Application No: M/82/20/HH
Site Address: 18 Manor Way Elmer Middleton-On-Sea PO22 6LA
Description of works: Single storey front extension, side extension and rear extension and first floor side extension, addition of a carport and changes to rendering and cladding

Thank you for your internet representation made on 11th December 2020 which has been recorded as an objection with the comments as follows:

In principle I support a refurbishment but the drawings submitted are not accurate and a number of uncertainties need to be clarified by the applicants:

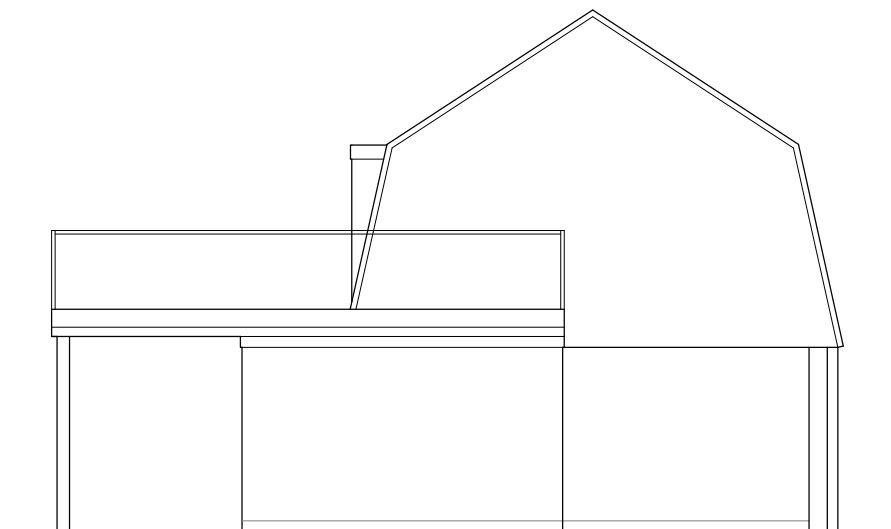
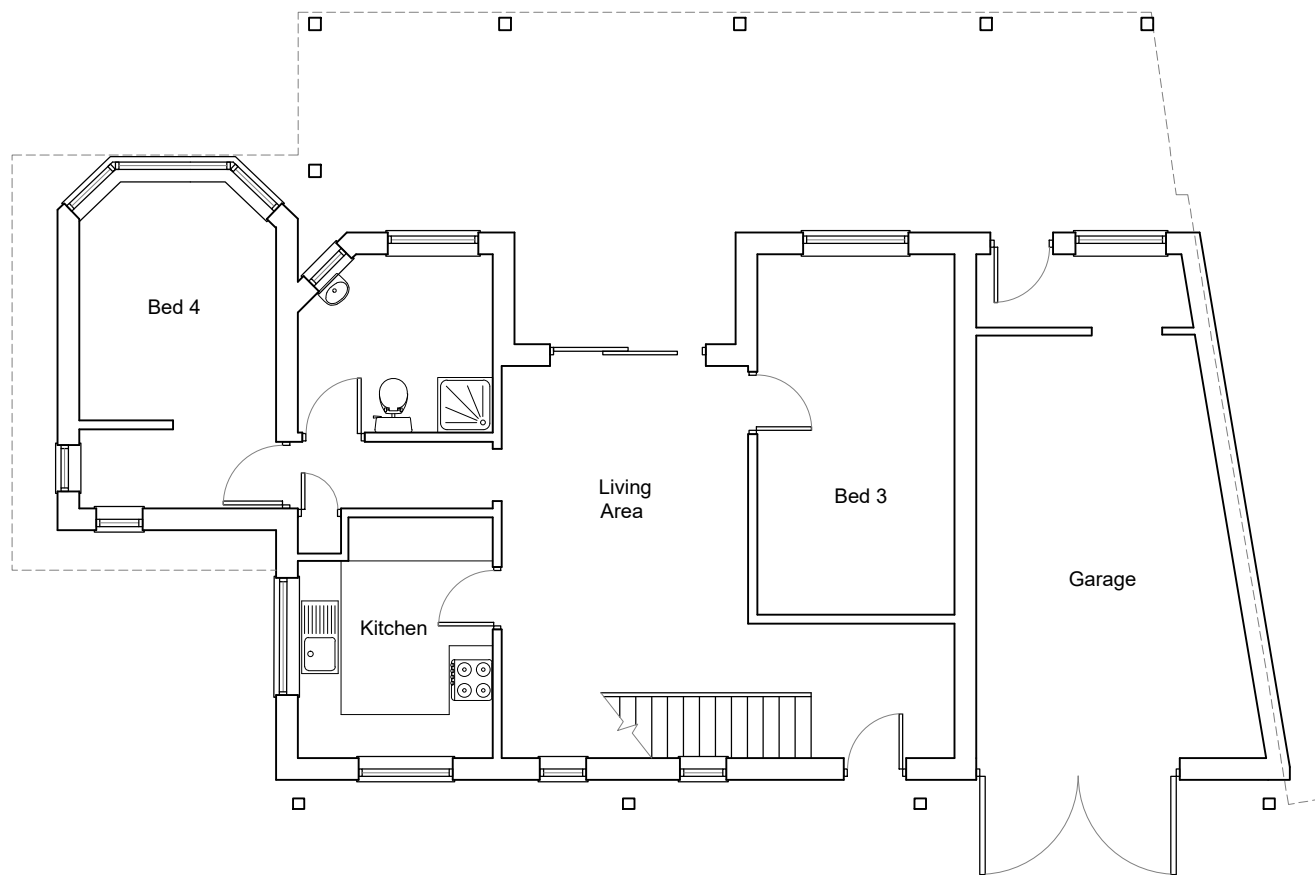
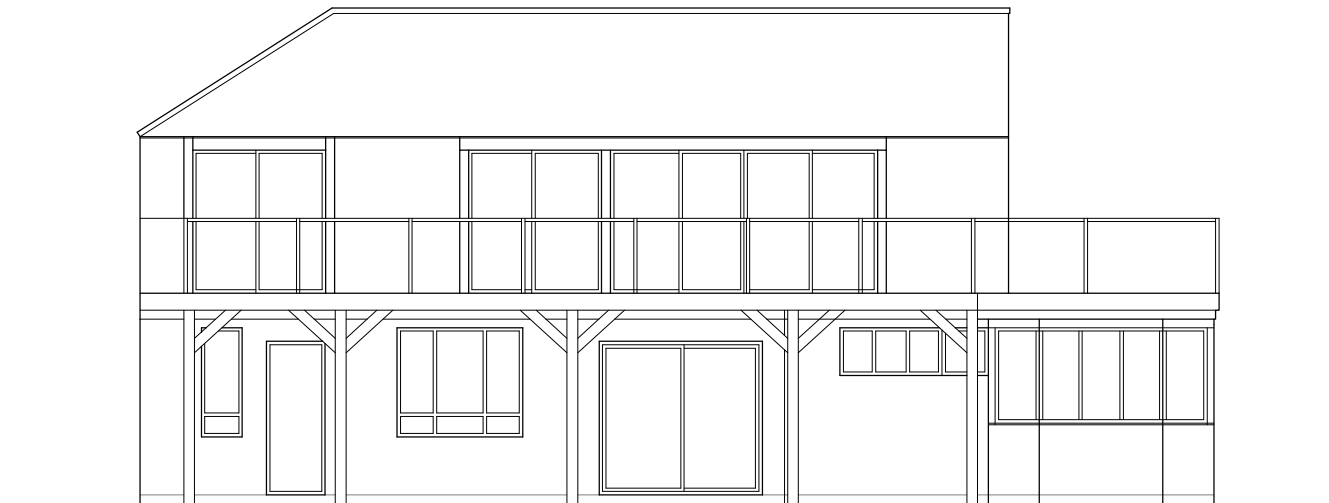
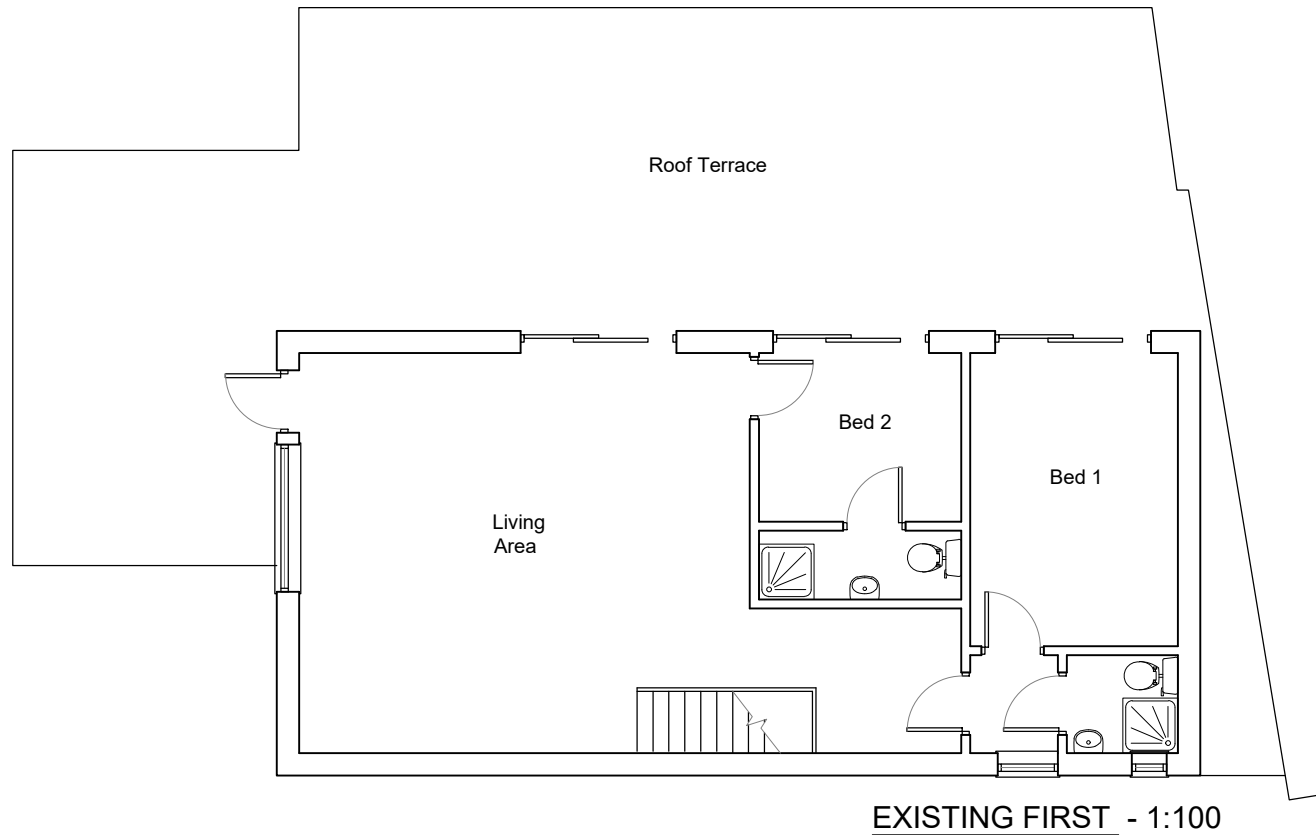
3. The existing balcony has an obscured privacy screen to prevent overlooking. This is not apparent on the proposed or existing drawings (which are again not accurate). When permission was given for a balcony in 2009 it was a condition that a 1.9m high privacy screen would be maintained to protect the amenity of my property. It is essential that this condition remains on a replacement balcony. This needs to be a minimum height of 1.9m and ideally 2.2m as no 18 is a lower ground level than no 16.

PROPOSED ROOF - 1:100

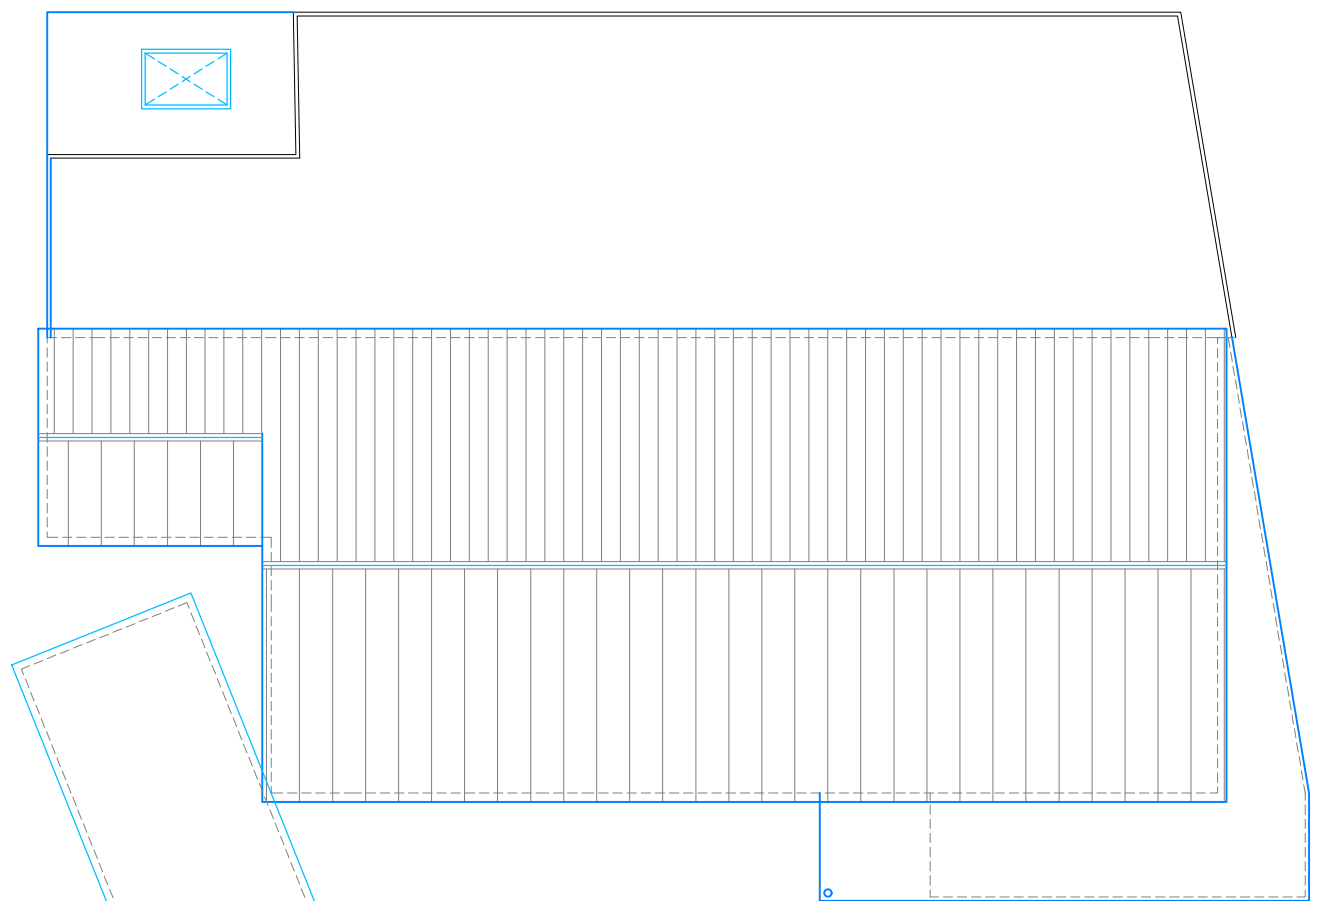
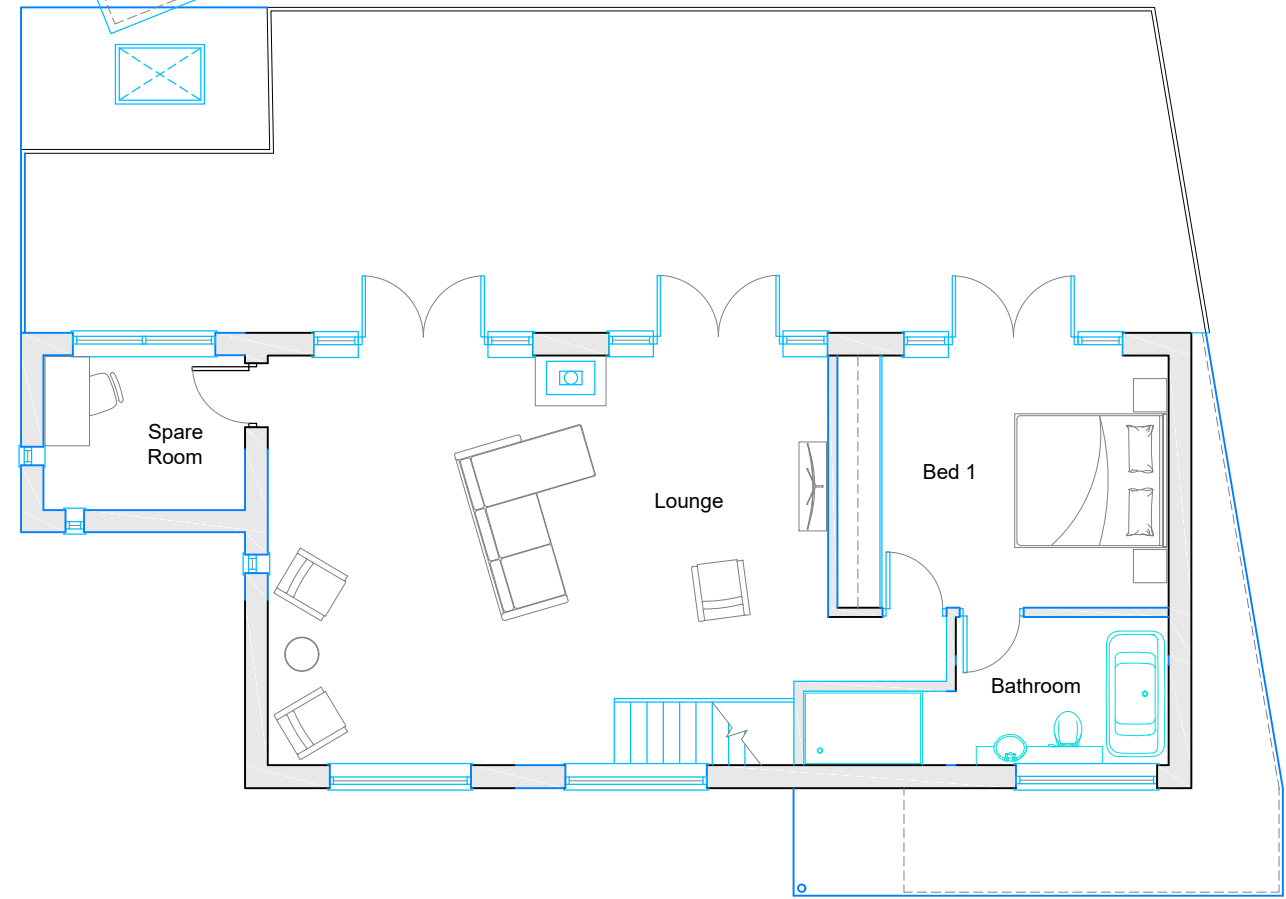
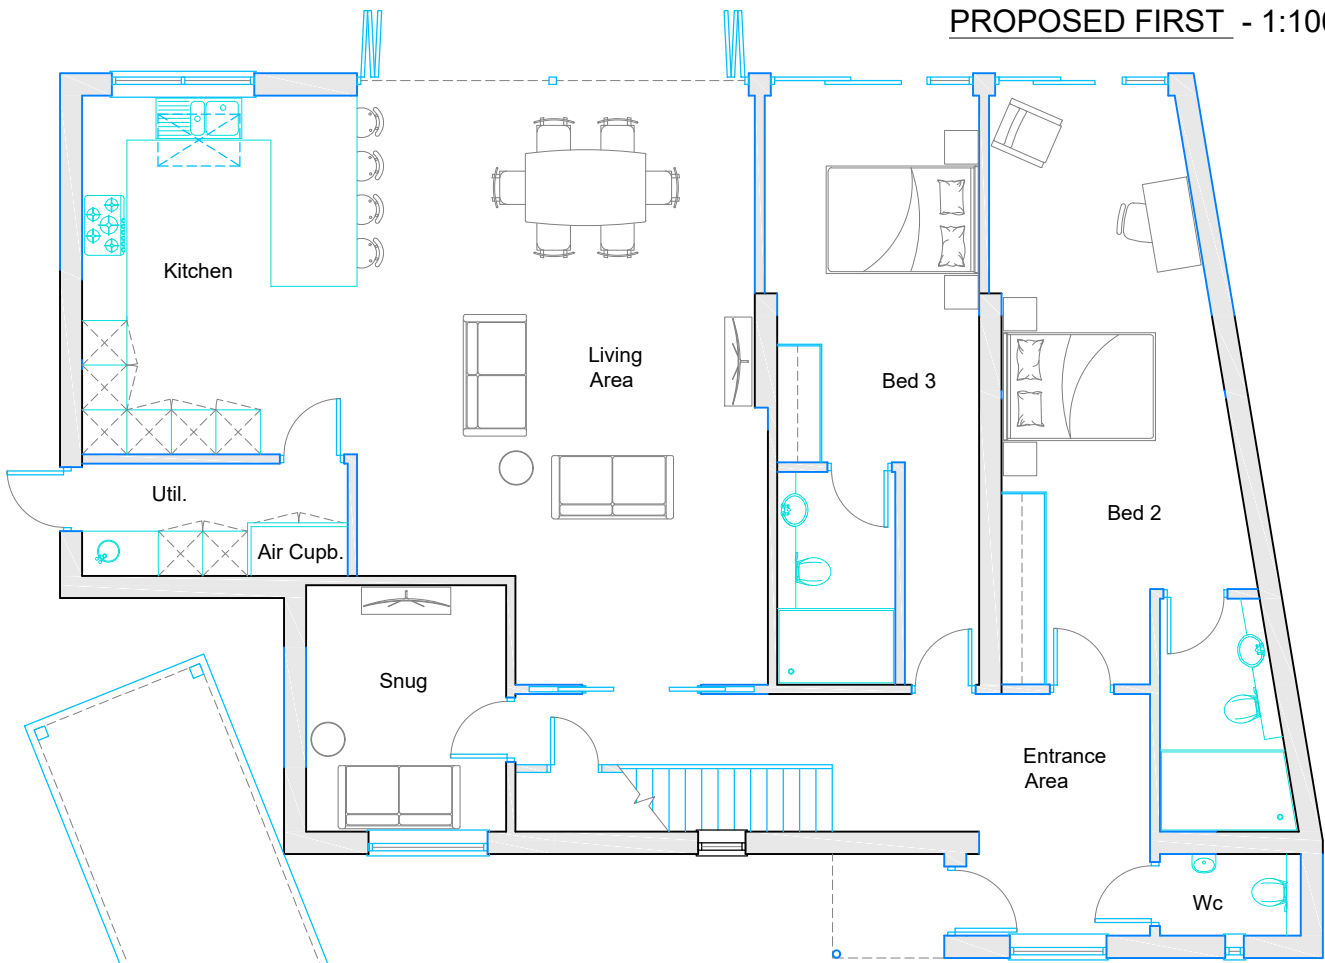
2. The proposed roof design is unclear from the drawings. There is a hipped roof shown on the elevations whereas a gable roof is shown on the roof plan, site plan and isometric drawing. The current roof adjacent to my property is hipped and I have no objection to this remaining. However, I would object to a gable roof as this will be imposing up against my boundary and will impact my property and the street scene. The applicants should clarify which of their proposed drawings are correct.

1. The drawings show the house as detached which is not accurate. No 18 joins onto my existing garage but this is not shown on the drawings. They need to clarify how they propose to deal with my existing garage. I have submitted a planning application (M8920HH) to demolish my existing garage and to rebuild leaving a 1m gap from the boundary so the properties can be properly detached. The proposed refurbishment will only be viable if my application is granted. The 2 applications need to be considered in conjunction with each other at the same time.

4. The applicants are proposing to build directly on the boundary between our 2 properties. The building will extend 2.8m beyond the existing joined garage into my garden as well as adding a porch on the boundary. This will involve demolishing the existing front boundary wall and back fence (which I jointly paid for and erected with the previous owner) and replacing it with a 3m high wall projecting 2.8m into my rear garden. The

FRONT ELEVATION - 1:100

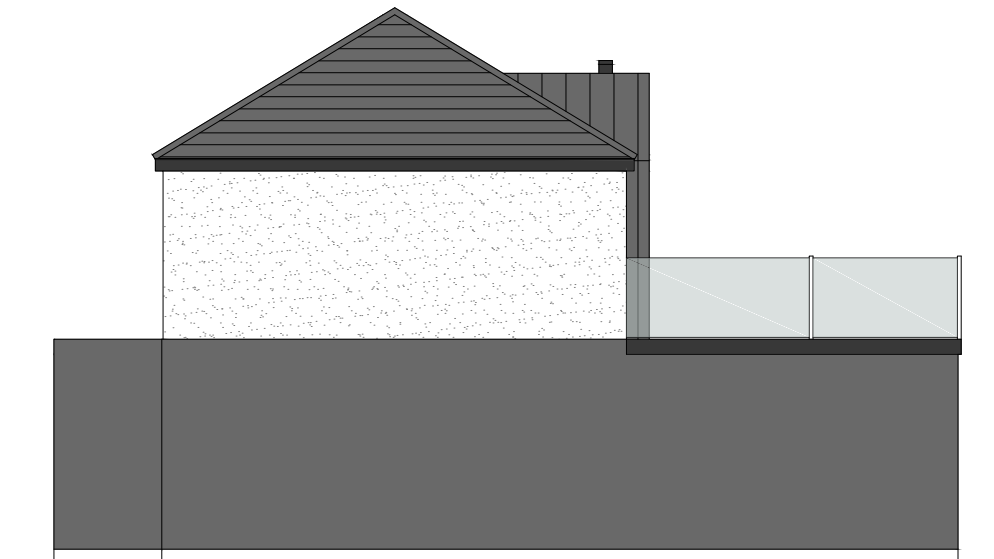
7. The drawings are unclear as to materials to be used on this imposing boundary wall. The application refers to white polymer render but the wall is shown "dark grey" on the drawing. It is not clear what material is proposed but if dark grey this would be very "prison like" along my boundary and projecting into my back garden. It is clearly not cedar cladding which would have the advantage of not requiring ongoing maintenance.
